## Appeal Decision

**Decision date: 4 February 2022**

**Appeal Ref: APP/R5510/W/21/3277165**

**Land Rear of Almond Avenue, Porters Way, West Drayton**

Title:
210 PROPOSED H3G SITE PLAN

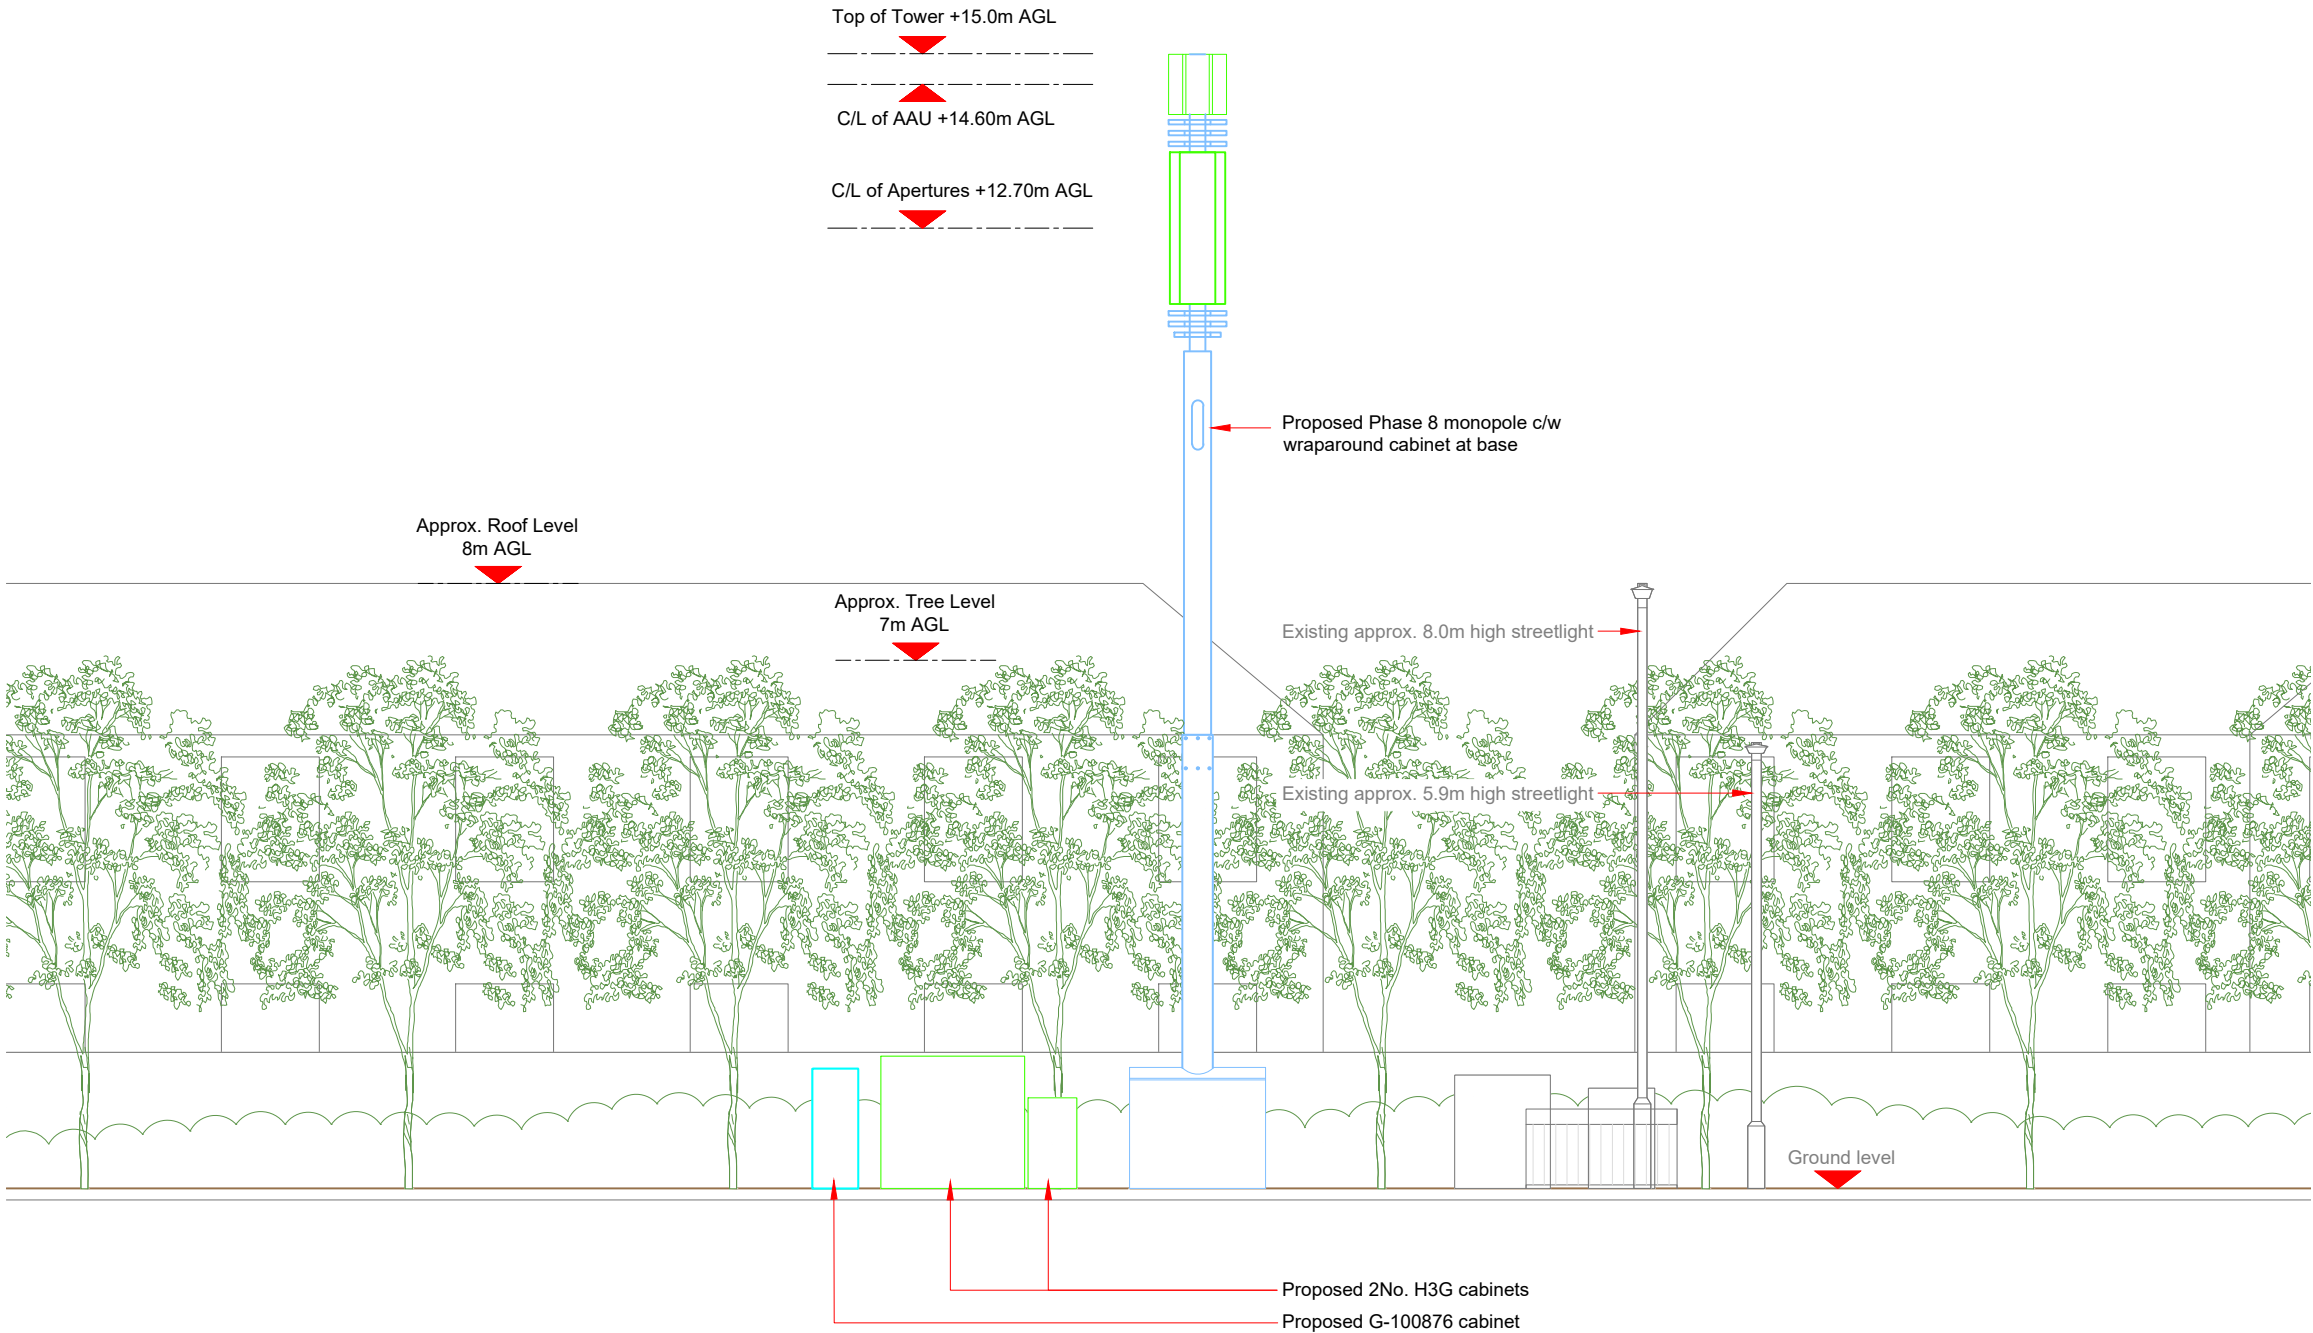
7. The scheme would be located on a grass verge close to the bend of Porters Way and Mulberry Parade. It would be adjacent to existing cabinets and a zebra crossing.

9. The appeal site has an open and spacious character as a result of the grass verge, nearby open grass area, gap to nearby building and Stockley Park Recreation Ground. The proposed monopole would be significantly higher than the nearby street furniture, including streetlights, CCTV poles and trees. The existing commercial and residential buildings would do little to screen the monopole because there would be a considerable gap between them and the proposal. Thus, the existing buildings and street furniture would not provide effective screening of the monopole due to their height and siting.

10. The monopole would be a dominant addition to the street scene because of the open nature of this part of Porters Way and Mulberry Parade. The scheme would appear as an obtrusive and incongruous addition to the local street scene. This is due to a combination of its siting, height and scale which would be seen in the context of the open character of the immediate surrounding area.

11. Although the appellant highlights that the associated ancillary equipment cabinets are within the size limits to be classified as permitted development without prior approval, the proposal before me relates to the whole installation. Owing to the combination of the existing cabinets, proposed cabinets and monopole, the scheme would add visual clutter to the detriment of the character of the area.
